**WAYNFLEET  
LOWER SCHOOL  
ADDITION & RENOVATIONS**

1 ADDENDUM 1 - GENERAL REVISIONS 01-30-2017

**LOWER SCHOOL  
FOUNDATION PLAN**

**S1.1R**

S1.1

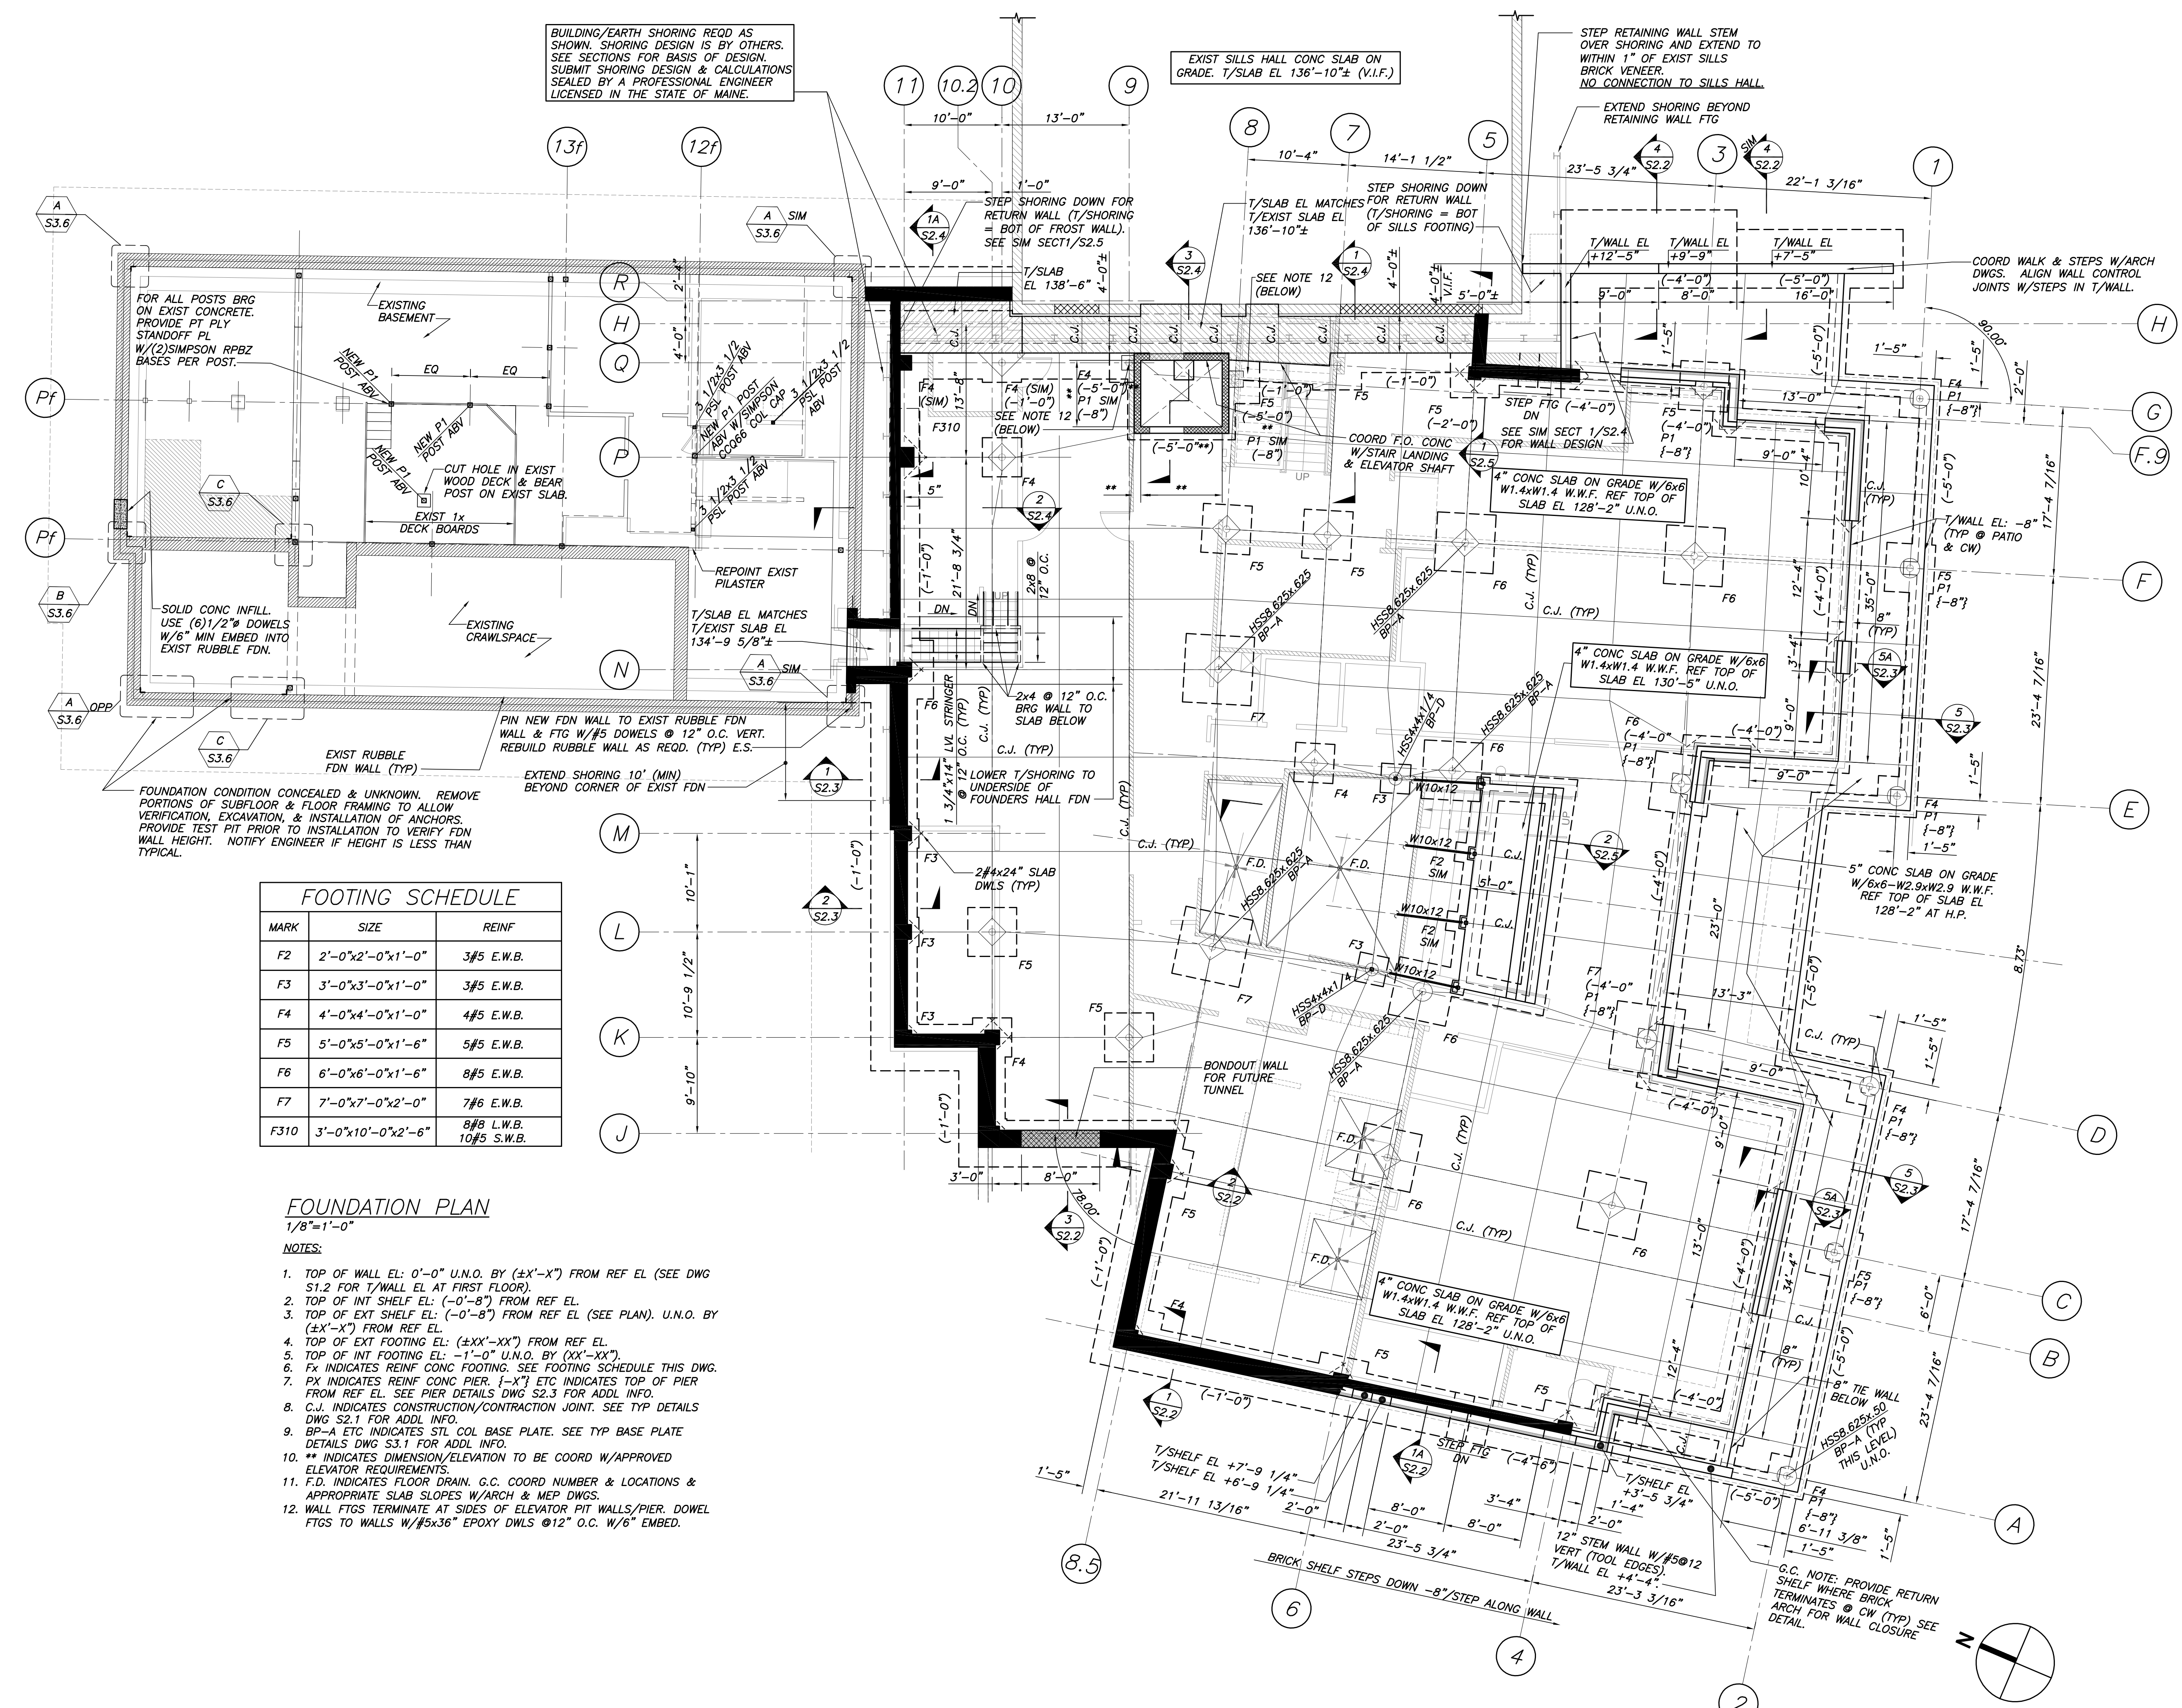
BUILDING/EARTH SHORING RECD AS SHOWN. SHORING DESIGN IS BY OTHERS. SEE SECTIONS FOR BASIS OF DESIGN. SUBMIT SHORING DESIGN & CALCULATIONS SEALED BY A PROFESSIONAL ENGINEER LICENSED IN THE STATE OF MAINE.

STEP RETAINING WALL STEM OVER SHORING AND EXTEND TO WITHIN 1" OF EXIST SILLS BRICK VENEER. NO CONNECTION TO SILLS HALL.

COORD WALK & STEPS W/ARCH DWGS. ALIGN WALL CONTROL JOINTS W/STEPS IN T/WALL.

COORD F.O. CONC W/STAIR LANDING & ELEVATOR SHAFT

4" CONC SLAB ON GRADE W/6x6 W1.4xW1.4 W.W.F. REF TOP OF SLAB EL 130'-5" U.N.O.

5" CONC SLAB ON GRADE W/6x6-W2.9xW2.9 W.W.F. REF TOP OF SLAB EL 128'-2" AT H.P.

4" CONC SLAB ON GRADE W/6x6 W1.4xW1.4 W.W.F. REF TOP OF SLAB EL 128'-2" U.N.O.

G.C. NOTE: PROVIDE RETURN SHELF WHERE BRICK ARCH FOR WALL CLOSURE
